## Application for a non-material amendment following a grant of planning permission. Town and Country Planning Act 1990

ALTERATIONS TO GROUND FLOOR UNIT AND FIRST FLOOR FLAT, AN INFILL EXTENSION AND CONVERSION OF GARAGE TO A COMMERCIAL UNIT

23/00295/PFUL3

## 8. Non-Material Amendment(s) Sought

Drawing No: 2421/06C

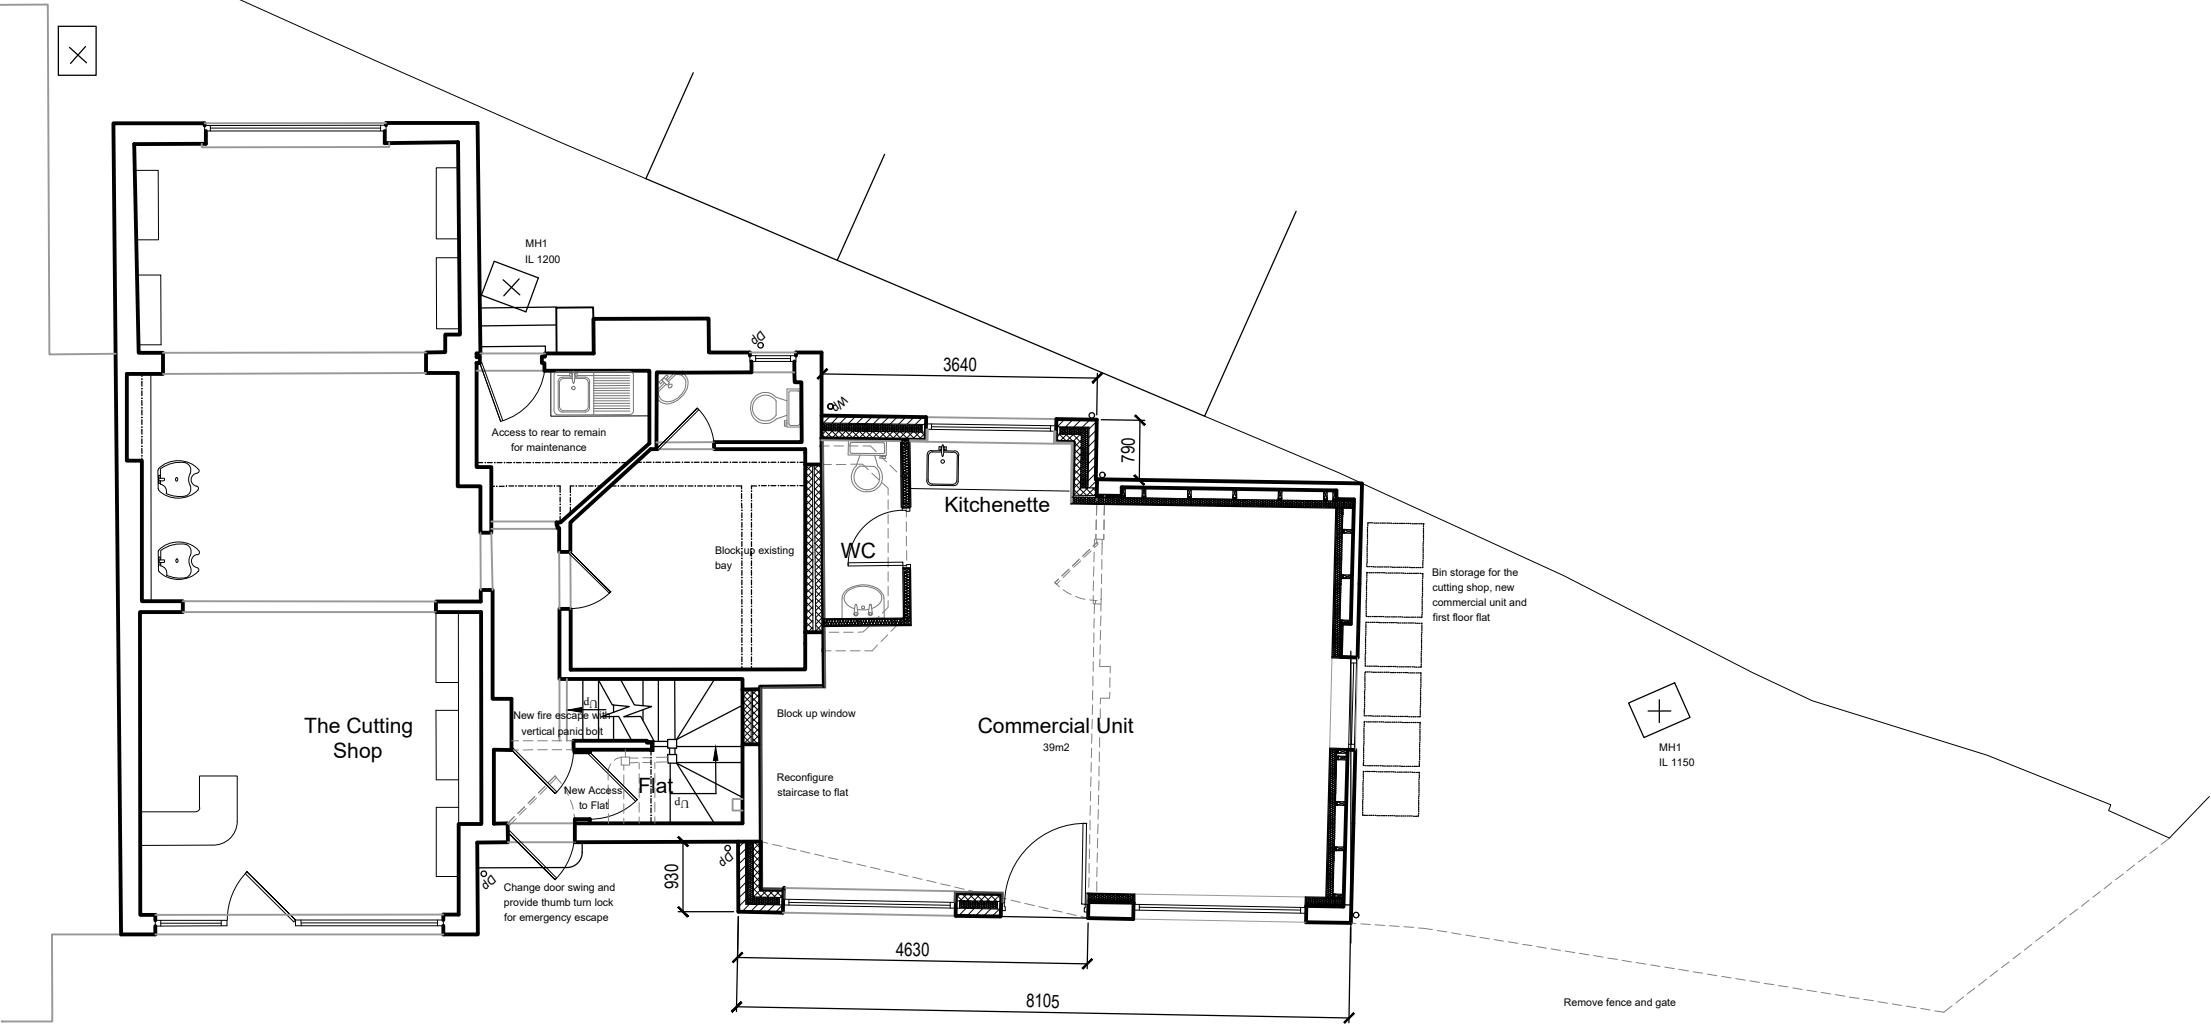
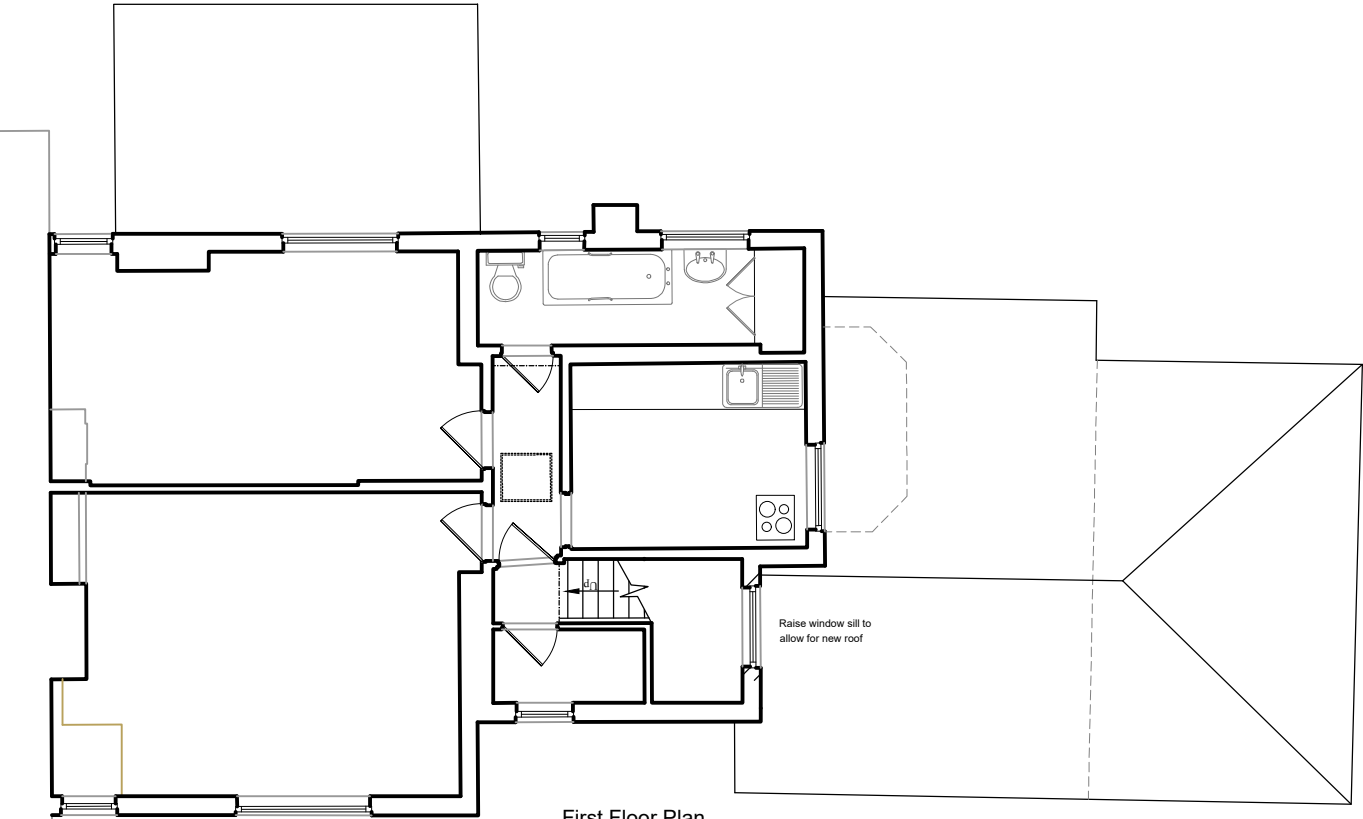
ROOF RIDGE AND EAVES HEIGHT INCREASED BY 100MM TO ACCOMMODATE THE SPECIFIED ROOF TRUSSES.

BRICK PIERS BETWEEN ENTRANCE DOORS AND FRONT WINDOWS.

BRICKS TO THE NEW COMMERCIAL UNIT SHOULD MATCH EXISTING GARAGE, WHICH WILL REMAIN AND FORM PART OF NEW UNIT. ORIGINAL DECISION NOTICE STATES THAT THE BRICKS SHOULD MATCH 505 HUCKNALL ROAD.
